Your Ref:
Our Ref: BR/148/11/
Please ask for:
Mrs S Leeson

5th July 2011

Application under Regulation 4 of the Town and Country Planning General Regulations 1992 to convert Glenlogie from a House of Multiple Occupancy into 8 self-contained apartments with associated external works. Demolition of Wee Glenlogie (also known as 10a & 10b) & the construction of 2 dwellings with parking in the rear garden
Glenlogie & Wee Glenlogie Clarence Road Bognor Regis

WEST (FRONT) ELEVATION 1:100

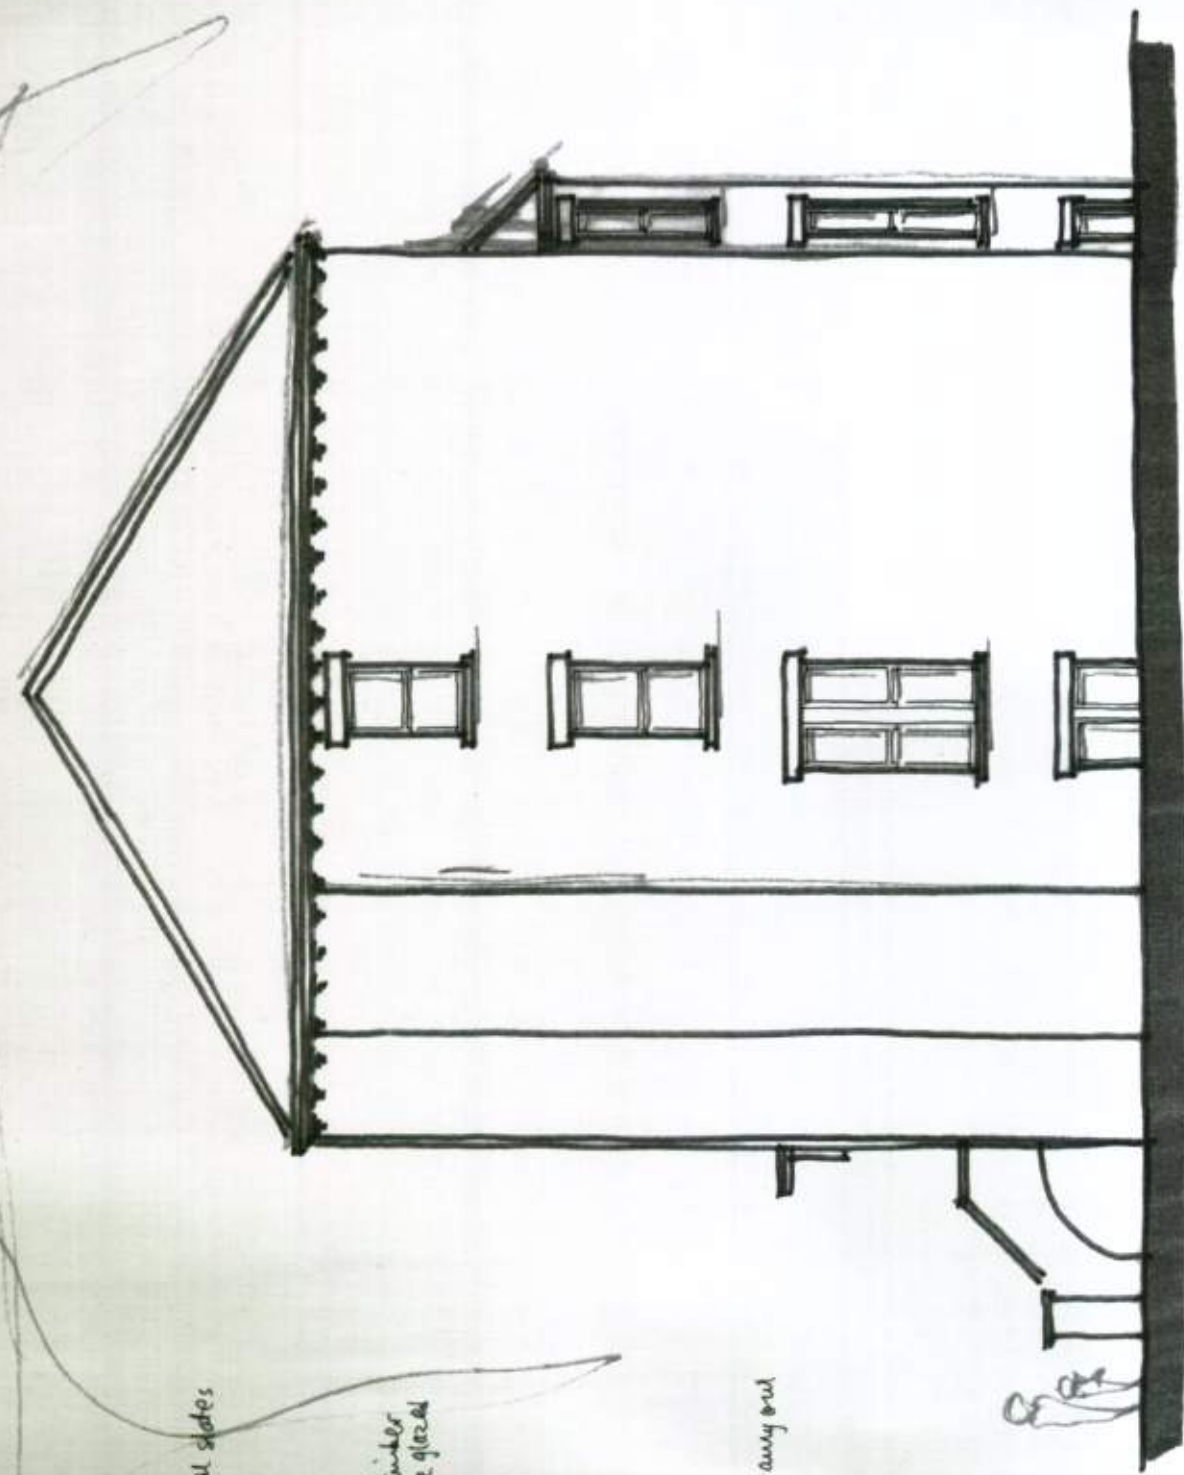
NO OBJECTION The Committee would like to see the wall on the High Street retained and the façade of Glenlogie
